Your Ref: OWPC20195
Our Ref: FP/201/18/PL 03-08-2018
Please ask for:
Richard Castro-Parker

1 No. dwelling.
Mermaid And Playbox Sea Road Felpham

Thank you for your internet representation made on 14th October 2018 which has been recorded as '**an objection**' with the comments as follows:

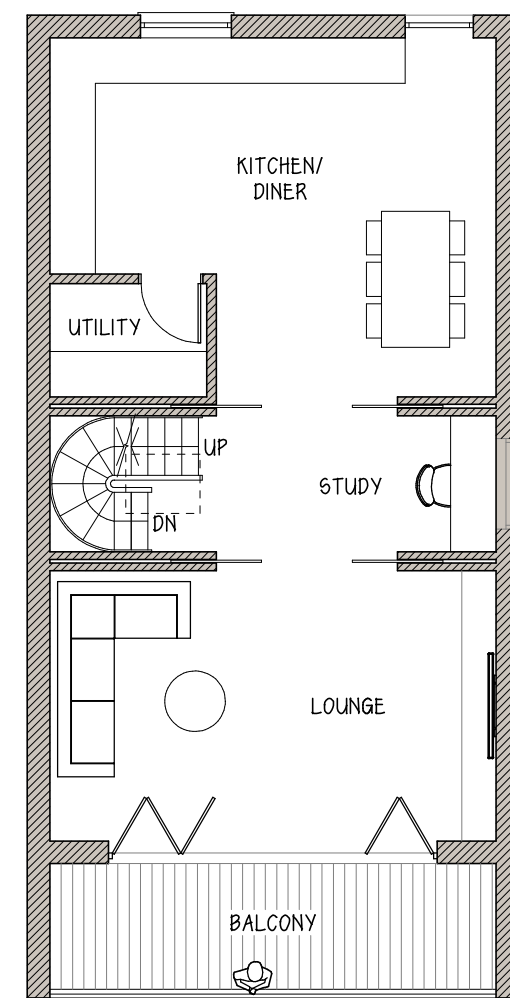
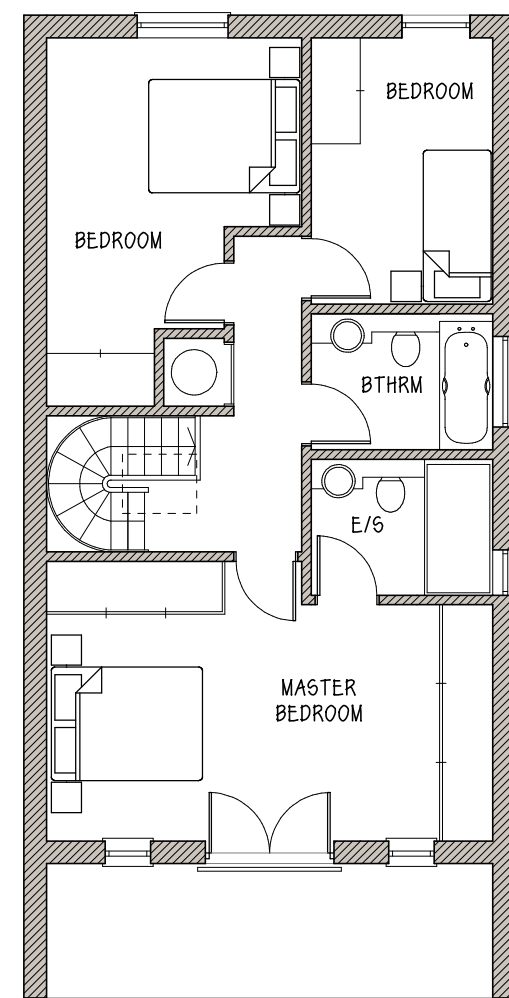
- 1. Far too tall out of character to previous dwellings and those in locality. Original single storey not ground first and second floor plus pitched roof.*

- 2. pitched roof instead of original flat roof.*
- 3. size and height of proposed dwelling will block out sunlight of Shingle End and Vihole railway carriages- causing darkness and loss of heat from sunlight.*

- 4. side door has been proposed where the original dwellings all have a front door- this will be out of character to other properties.*
- 5. Land at the front is shared by all 9 plots and can not be taken by one land owner for their development, therefore the plans have a problem with amount of land actually available to build on.*

- 6. original dwellings were single storey and not 4 flats of more than a one storey.*
- 7. Access at rear is restricted, for building, that will be building problem later on as access will not be granted.*
